PLANNING WORKSHEET 11 – DELEGATED / PCG REPORT - HOUSEHOLDER

Application Ref.	22/00666/HSE	
Site Address	18 Station Avenue Ranskill Retford Nottinghamshire DN22 8LF	
Proposal	Two Storey Side Extension	
Case Officer	Eleanor Grant	
Decision Level	Delegated	
Reason(s) for PCG referral		
PCG Sign off and date		
	Signature	Date
Case Officer	Ellie Grant	05/07/2022
Principal Planner		
Authorised signing Manager		7 th July 2022

CLIENT:	Mr and Mrs Kilby.
SITE ADDRESS:	18 Station Avenue. RANSKILL. Retford. DN22 8FL. Nottinghamshire.
PROJECT:	Proposed Extensions and Alterations to Existing Dwelling.
SCALE:	1: 100 @ A3
TITLE:	Elevations as Proposed.
DATE:	MAY 2022
Drawing Number 22-07 Ref: KILBY

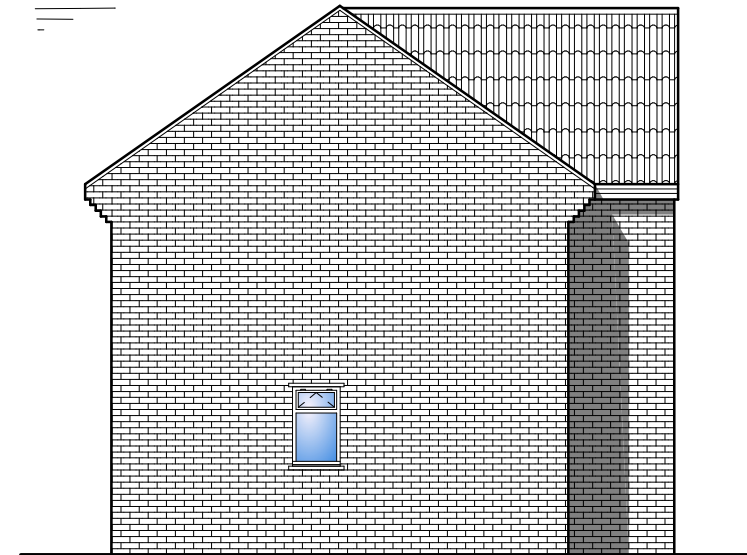
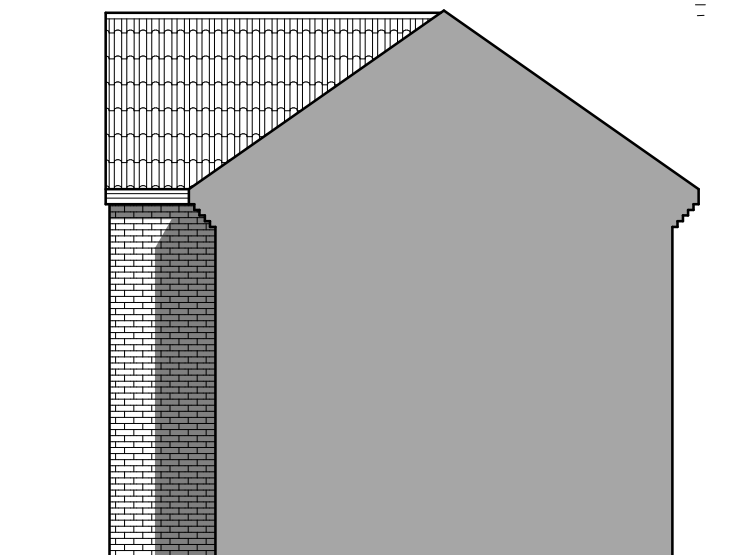
The extension will be constructed of brick and have a pitched roof which is set at 90 degrees to the front projecting gable. It will be set back from the gable, in line with the neighbouring dwelling. This will unify the appearance with the existing arrangement.

The extension will be of a reasonable scale and will integrate well with the main dwelling and wider setting. The windows will be of a similar size and appearance to those on the original dwelling.

Rear Elevation as Proposed.

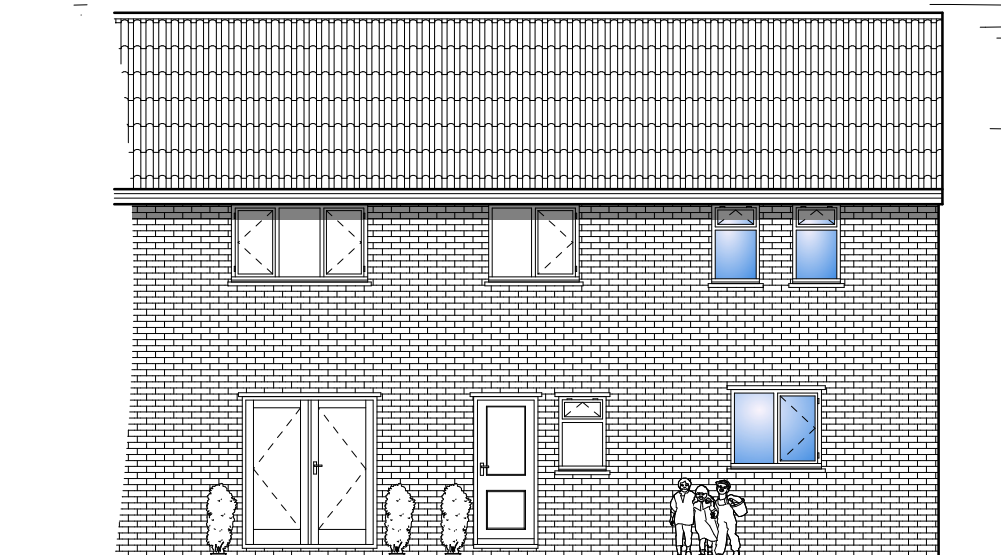
As the property sits on a corner plot at a junction, there are a limited number of properties in close proximity. However, the rear elevation of the extension will be directly facing towards the side elevation of 20 Cherry Tree Close. 20 Cherry Tree Close has a two storey side extension which has a side window facing the rear elevation of the application site. There are two first floor windows proposed in the extended area therefore overlooking must be considered. The first floor windows will serve an en-suite and bedroom. These will be small windows and will offer some views towards the side window of the neighbouring dwelling which is approximately 13 metres away. As such, it has been agreed that these windows will be obscurely glazed.
